COLORADO GEOLOGICAL SURVEY

August 29, 2018

Subject: Sterling Ranch Filing No. 2, Final Plat, File No. SF1820
El Paso County, CO; CGS Unique No. EP-19-0014

The Colorado Geological Survey (CGS) has reviewed the Final Plat submittal for Sterling Ranch Filing No. 2. We understand from the letter of intent that the Final Plat includes 49 single-family lots, 1 tract for future residential lots, 10 tracts for landscaping, public improvements and public utilities, the widening of Vollmer Road adjacent to the filing, and the construction of Marksheffel and Sterling Ranch Road within the filing. CGS previously reviewed the Sterling Ranch Sketch Plan in our letter dated December 19, 2007.

FINAL PLAT  
STERLING RANCH FILING NO. 2  
JOB NO. 09-004  
DATE PREPARED: 02/26/2018  
DATE REVISED:

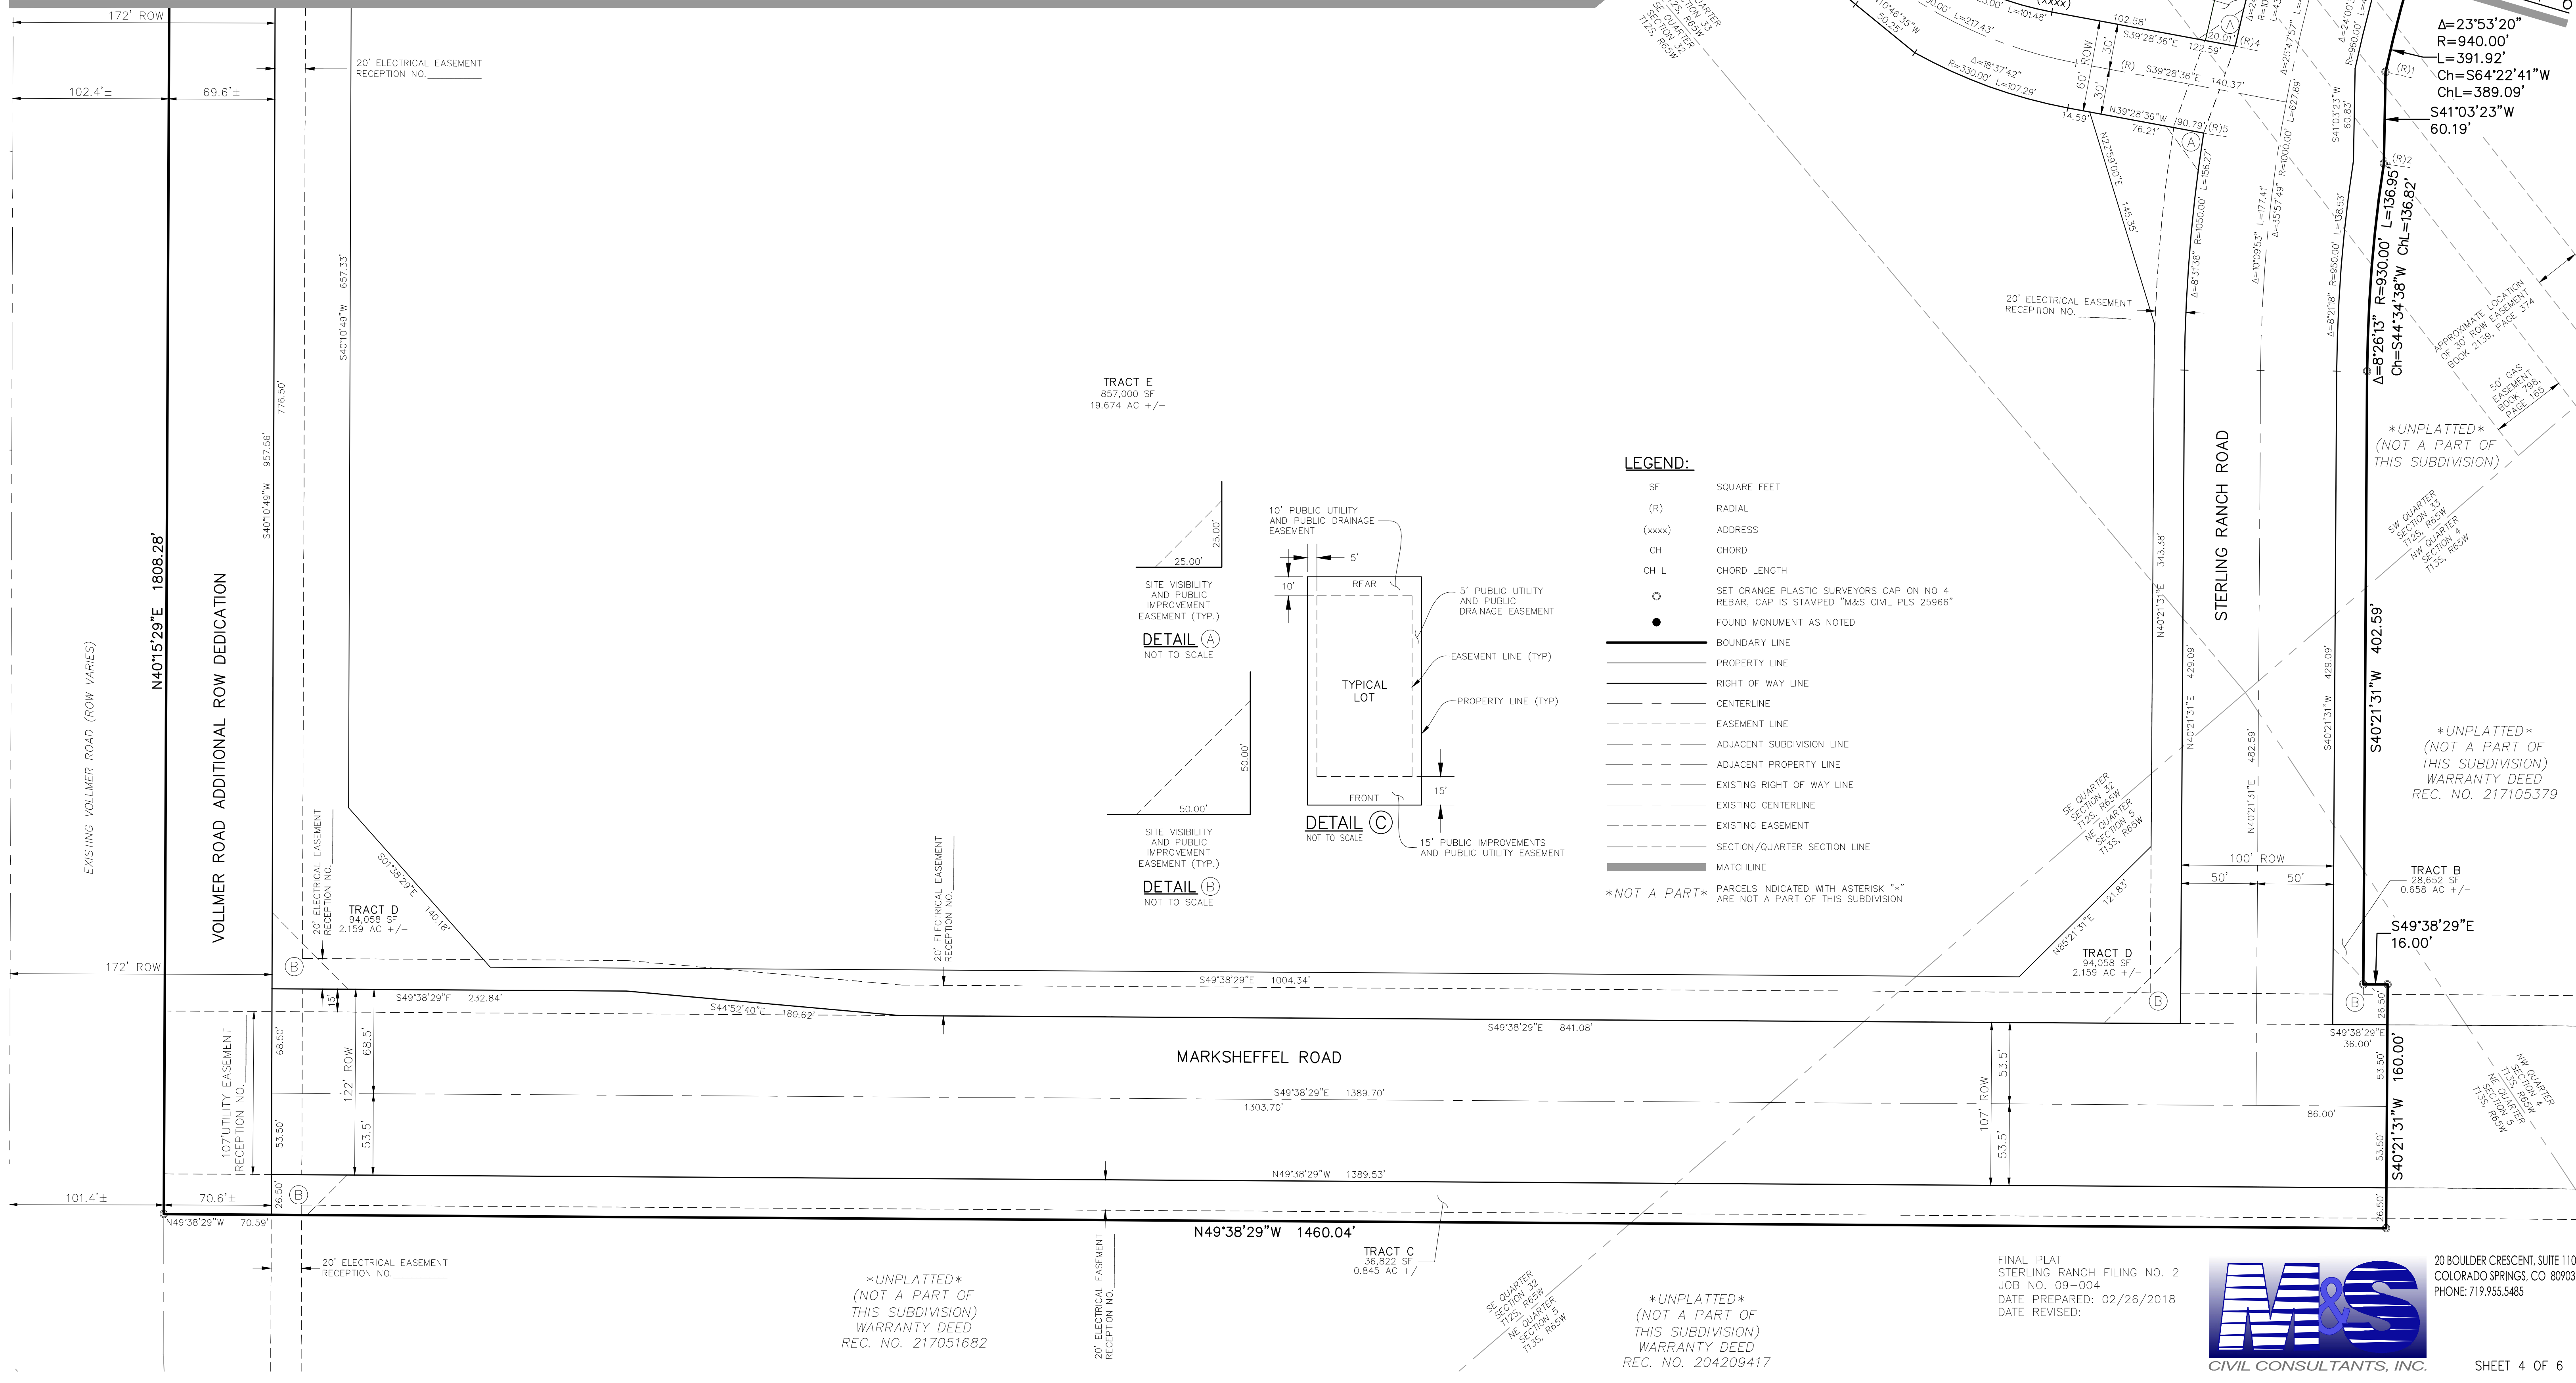
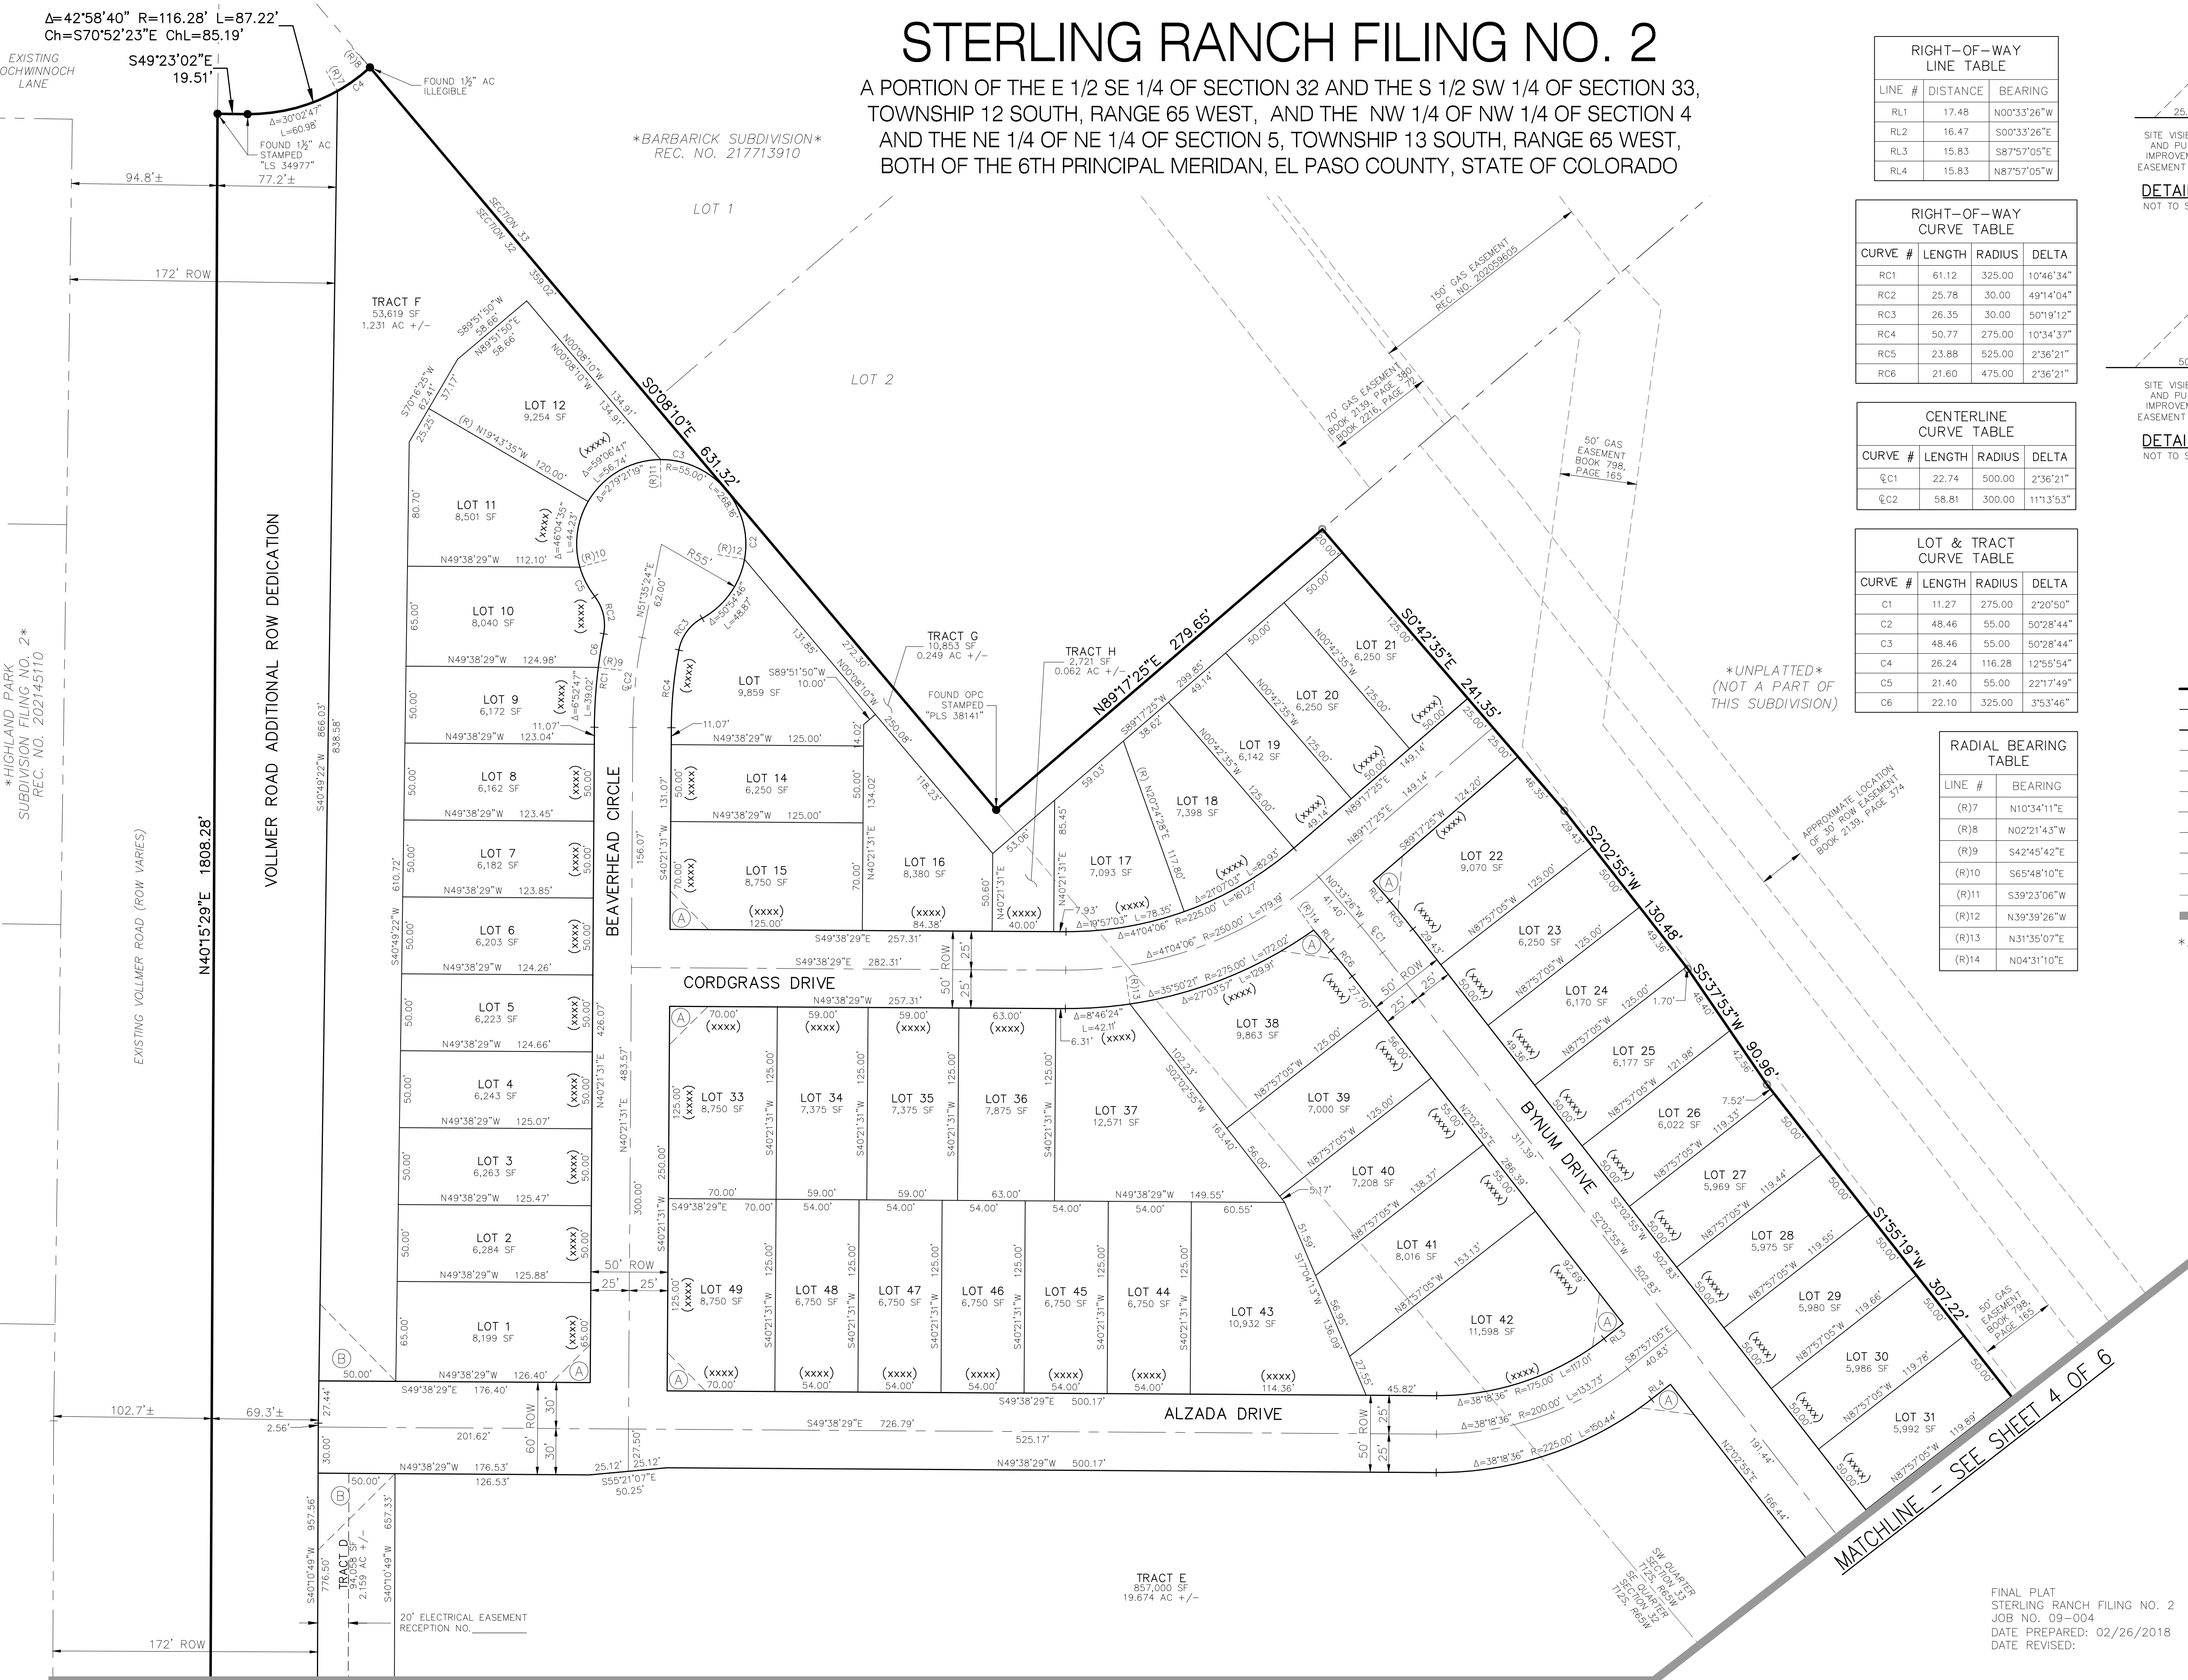
Geologic Hazard Report and Final Plat: Entech's report(s) identify areas of geologic hazards and provides preliminary conceptual plans for mitigation of these hazards. An unnumbered plat note between notes 25 and 26 states: "*The following lots and tracts have been found to be impacted by geologic hazards. Mitigation measures and a map of the hazard area can be found in the report (Entech, 2009) ...The following lots and tracts are impacted: Unstable slopes: Lots 21 through 30 Shallow groundwater: Tracts C, D and E Seasonal shallow groundwater: Tracts B, D, I, and J*". The copies of the geotechnical reports we received do not include all the figures. Figure 5 and 8 are missing from the 2009 report. Figure 5 (2009 report) is the Development Plan/Test Boring Location Plan and Figure 8 (2009 report) is the Geology Map/Engineering Geology map. We are unable to verify that the areas identified with geologic hazards by Entech are the same areas discussed in the plat notes. We would appreciate the opportunity to review these figures compiled by Entech.

We recommend that the geotechnical engineer provide engineering recommendations based on the Final Plat,

Grading and Drainage Plans for at least the following issues:

- the location of preliminary building setback lines in unstable and potentially unstable slope areas, and/or comments on planned site grading and if it will mitigate these (and other) hazards, and
- feasibility of basements in areas of seasonal and permanent shallow groundwater

These geotechnical recommendations should evaluate both the proposed lots and tracts and be included in the plat notes.

These plans reference a soils report by CTL Thompson. If a report has been prepared by CTL Thompson we recommend that it be submitted for review or the reference be changed to the report of record (i.e. Entech). The grading plan states in note 27 that a portion of the property "*is located within a designated FEMA floodplain...*" We can find no indication of this on the plat.
